**Our Case Number:** ACP-323836-25

**Re:** The proposed development consists of the construction of a new Footbridge and resurfacing of existing lane with walkway link to the existing park in the form of new footpaths and all ancillary site works as required to complete the works.  
Newport Ball Alley and Park, Newport, Co Tipperary.

**Objection to the Planning Notice for the Newport Ball Alley Footbridge, REF ACP323836**

Proposed Site Plan

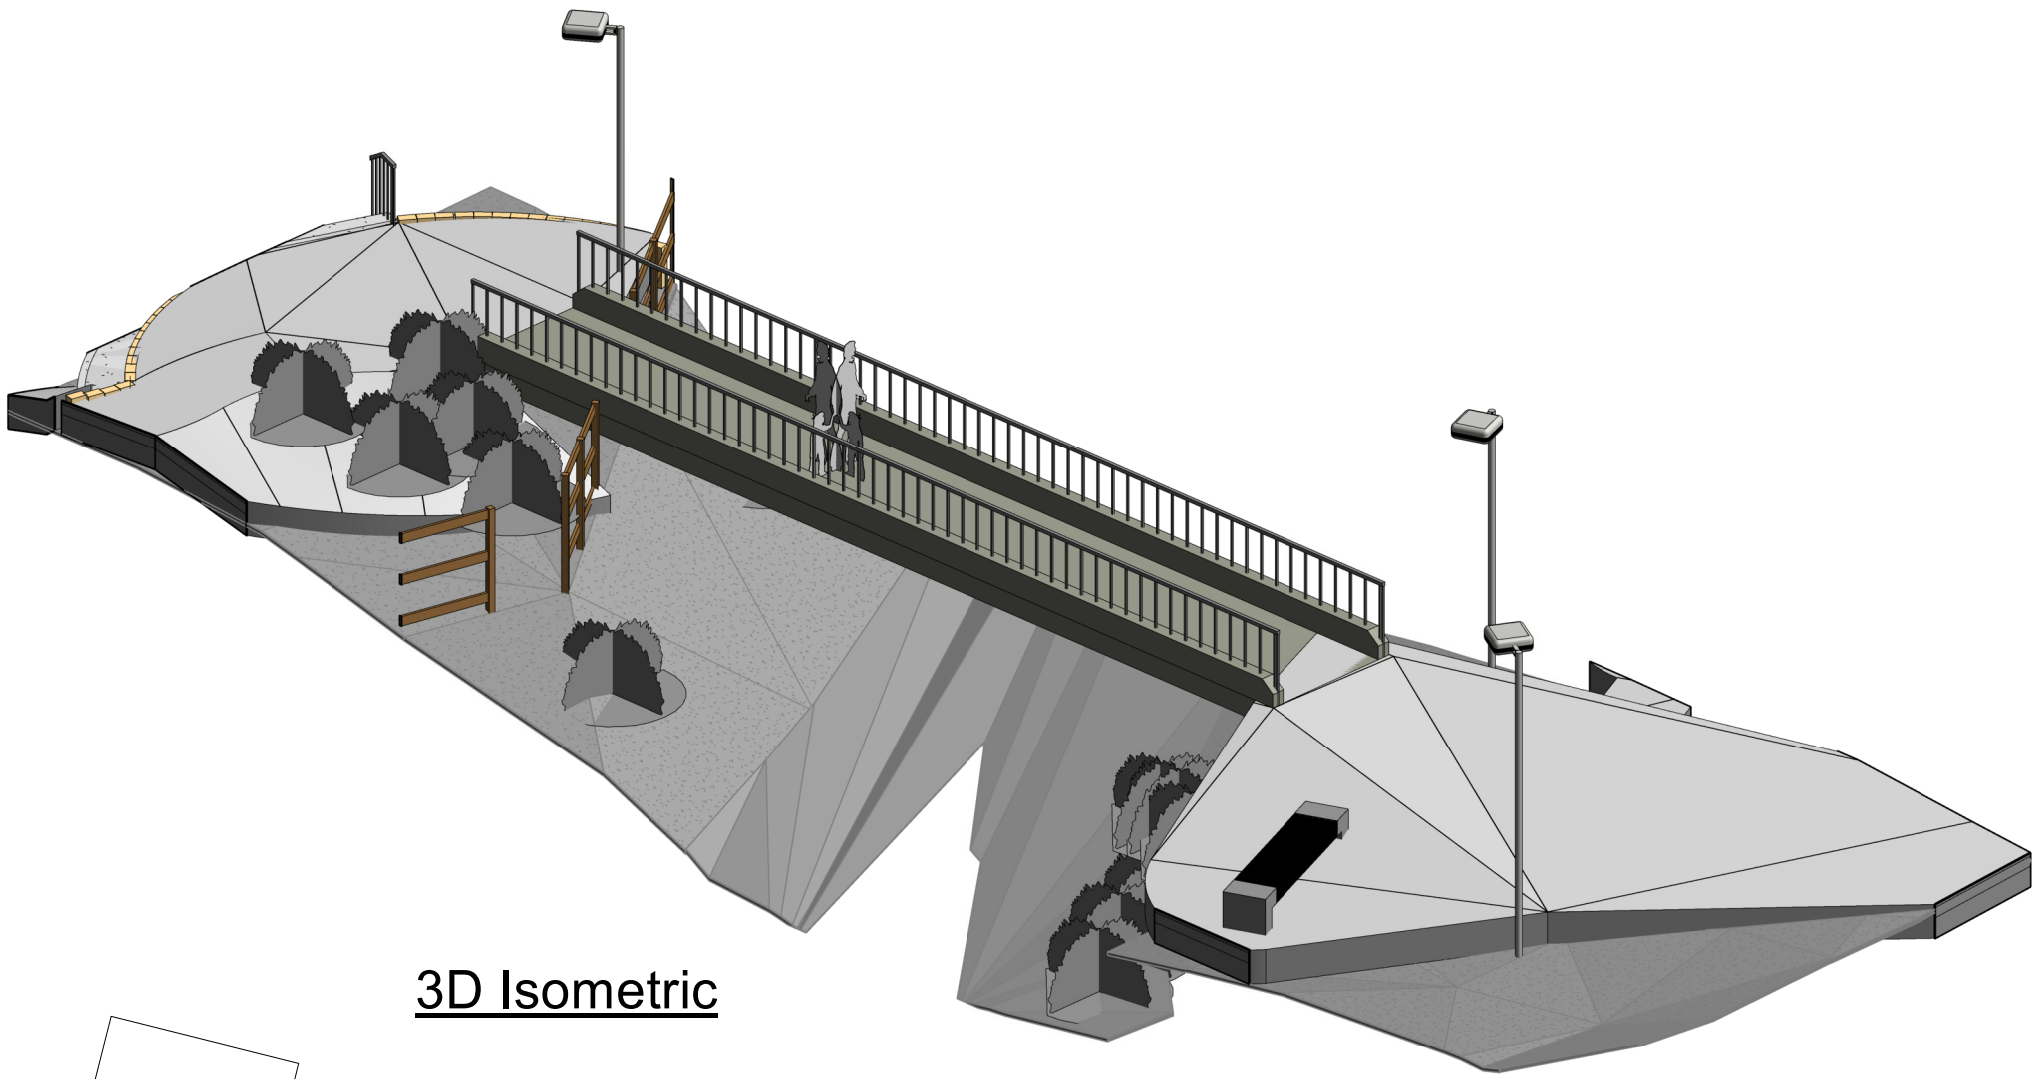
Our concern is, the proposed footbridge would create a link from the ball alley directly to the rear of our property, to a very secluded area of the town. This secluded area is the proposed picnic bench area, to the rear of our property. We fear this would become an extension of the current loitering area and therefore the antisocial behaviour it enables.

Furthermore, the laneway which will join the proposed the picnic bench area to the centre of the town, is narrow and steep. It is not an inviting access route for the members of the public to avail of because of the steep incline. This reaffirms our fear that the area to the rear of our property will only be an extension of the current antisocial behaviour and will not be used by members of the public, as it is hidden from view.

A further concern involves the existing access route to the ball alley, as this access appears to belong to a private property. Because of this, we fear this access route may be closed off once the new development is in place. The potential closure of the access route causes concerns as we fear all the antisocial behaviour would pass via the side and rear of our property to the ball alley, causing further disruptions.

Proposed Plan

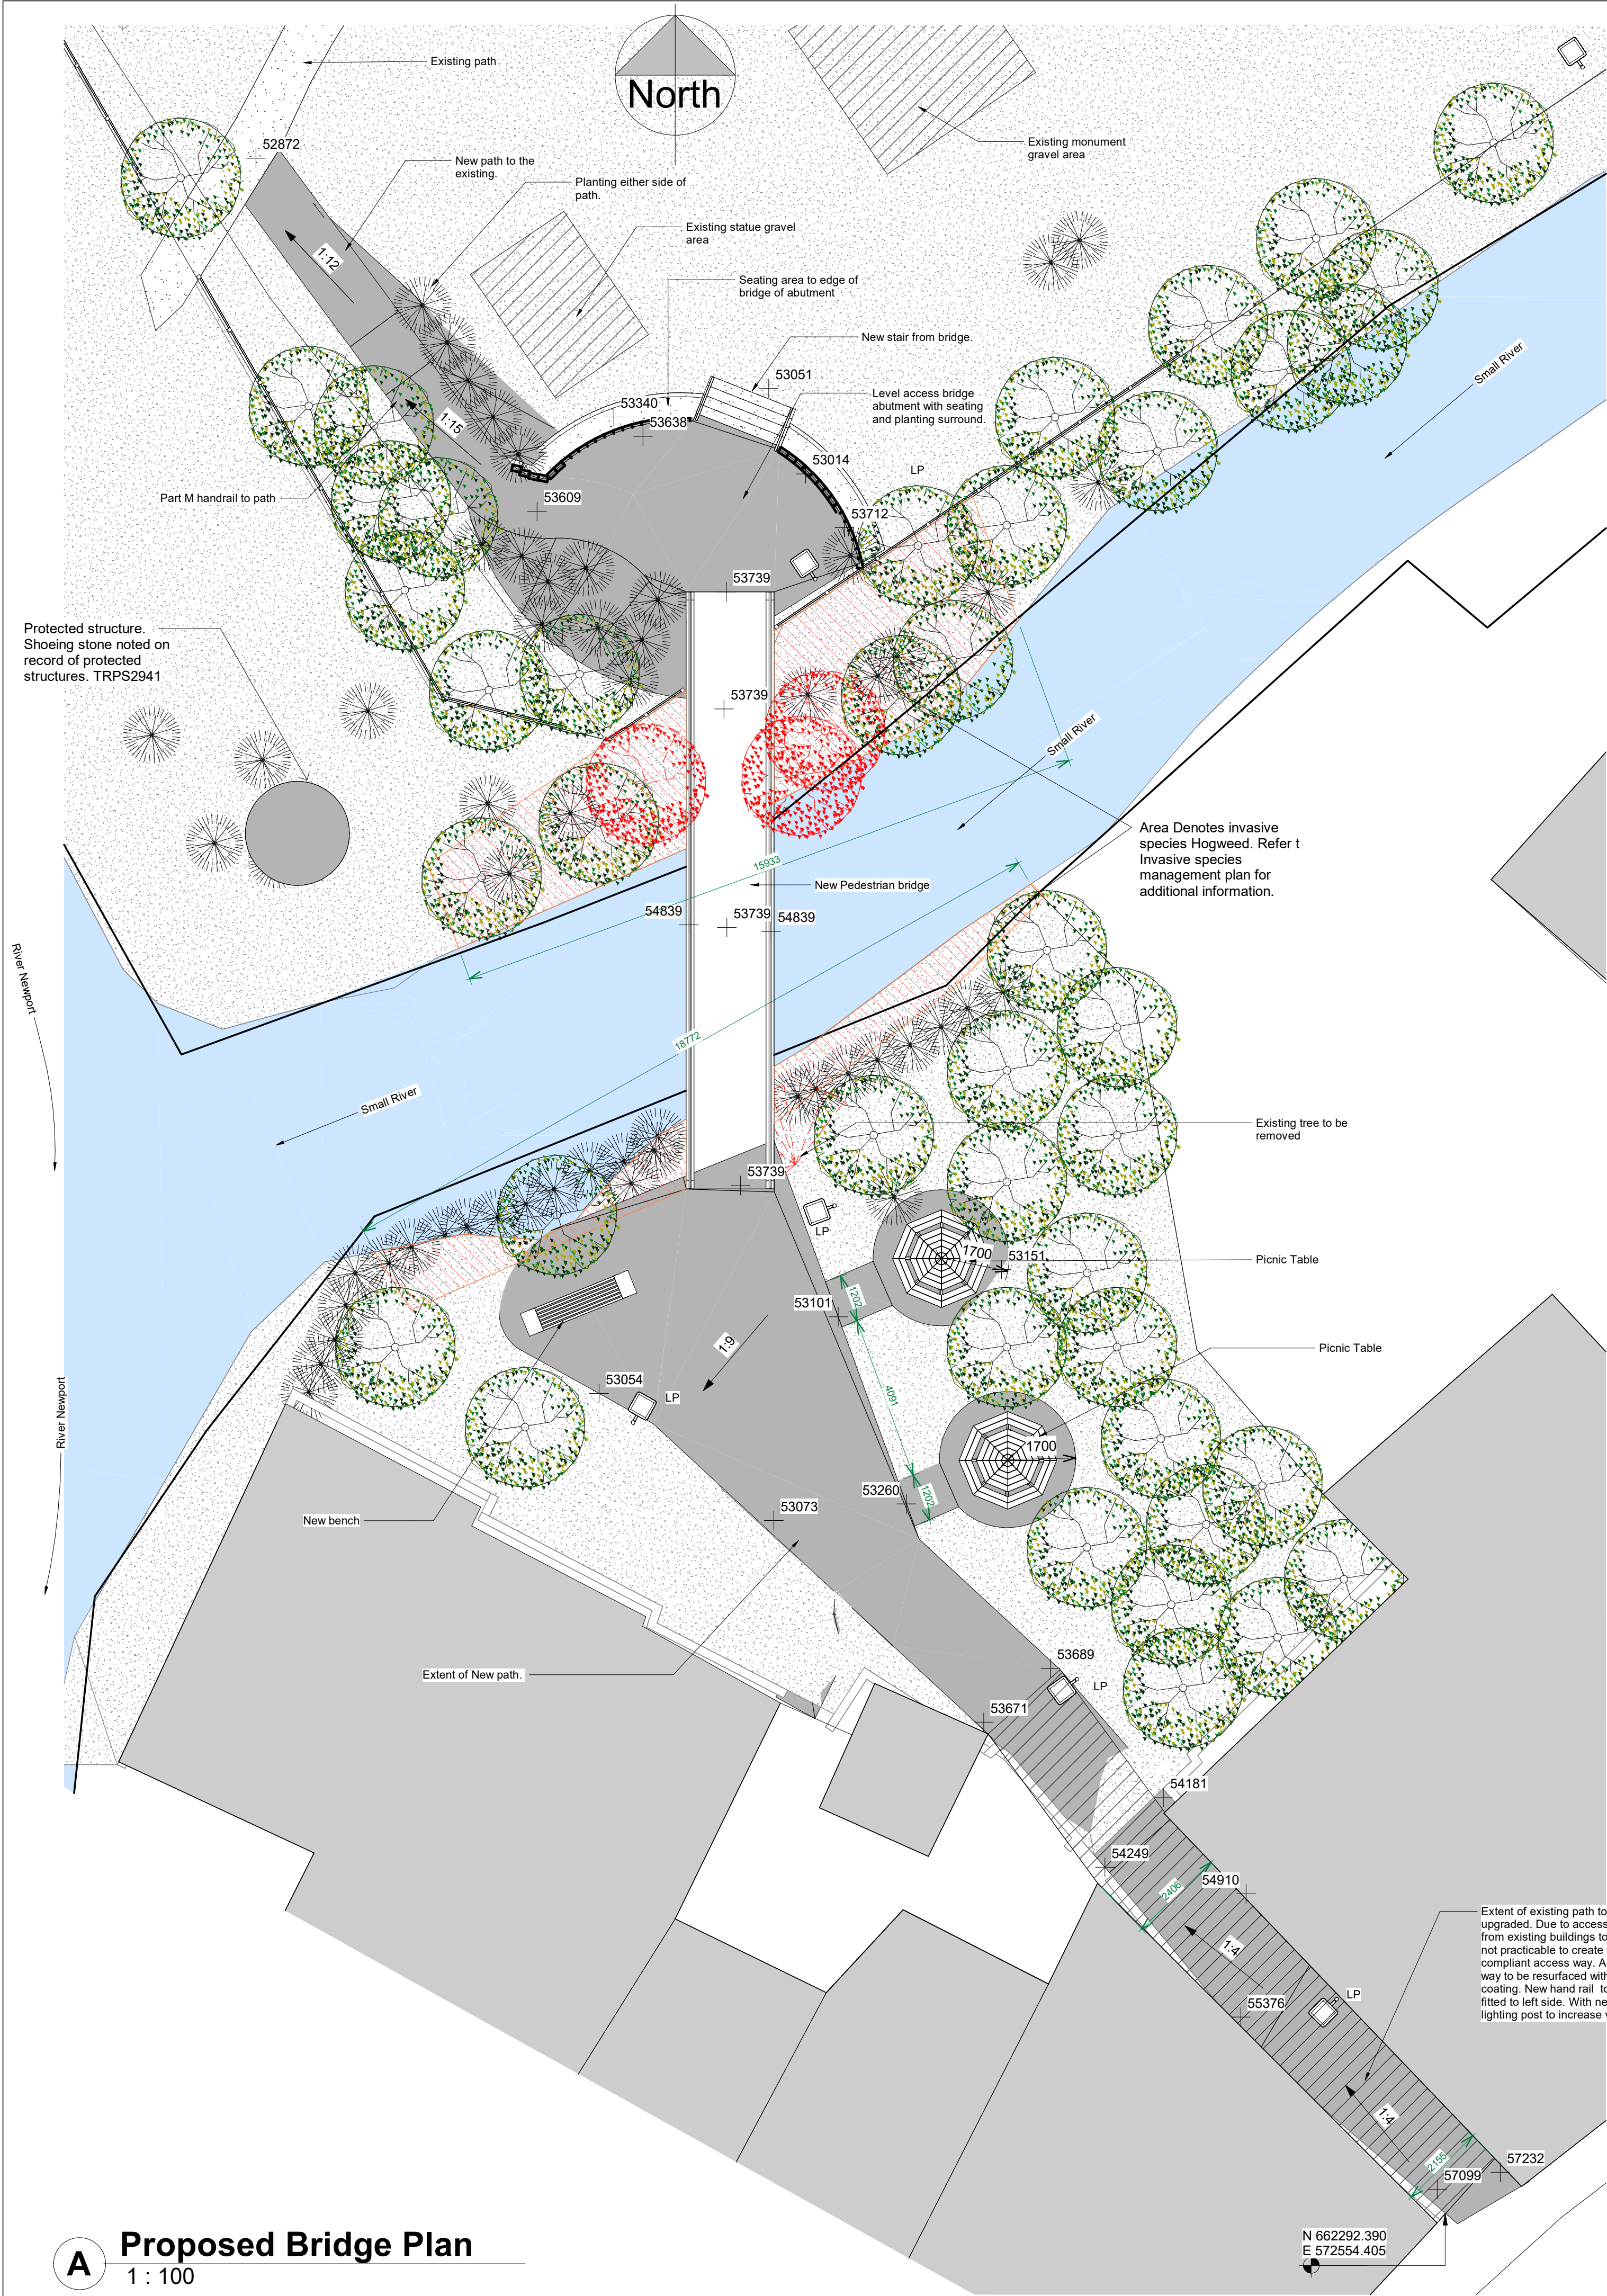
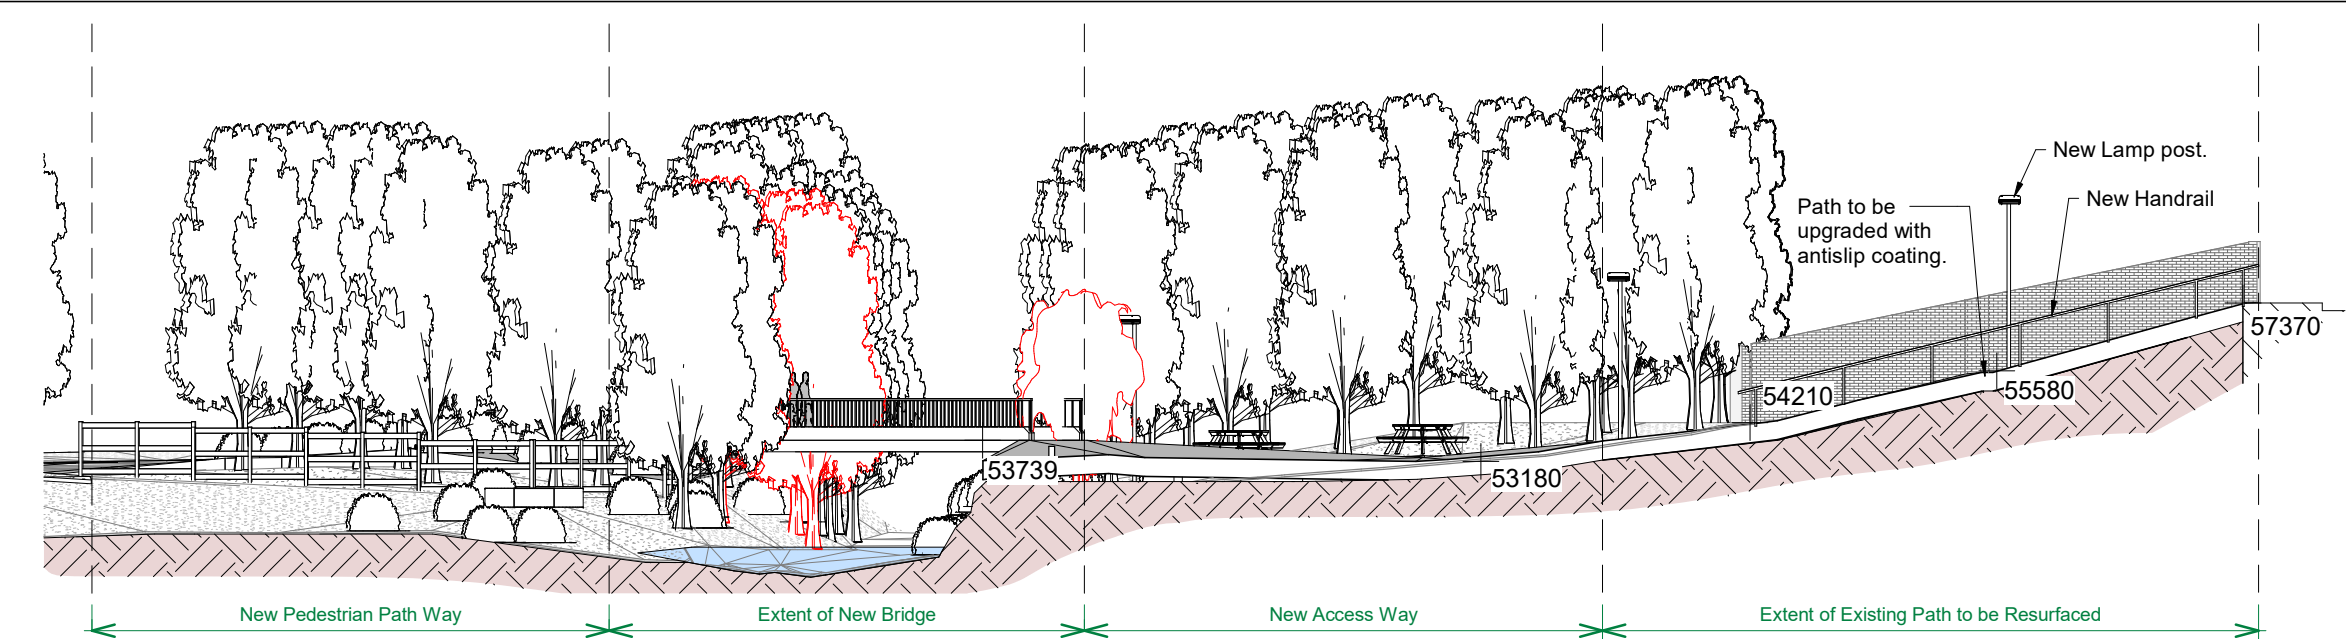
We would also like to note at this laneway is a service corridor for the properties that back onto it. The proposed handrail would narrow the access for those needing to use the laneway to service the rear of our properties. For example, access for maintenance, storage of waste bins, etc.
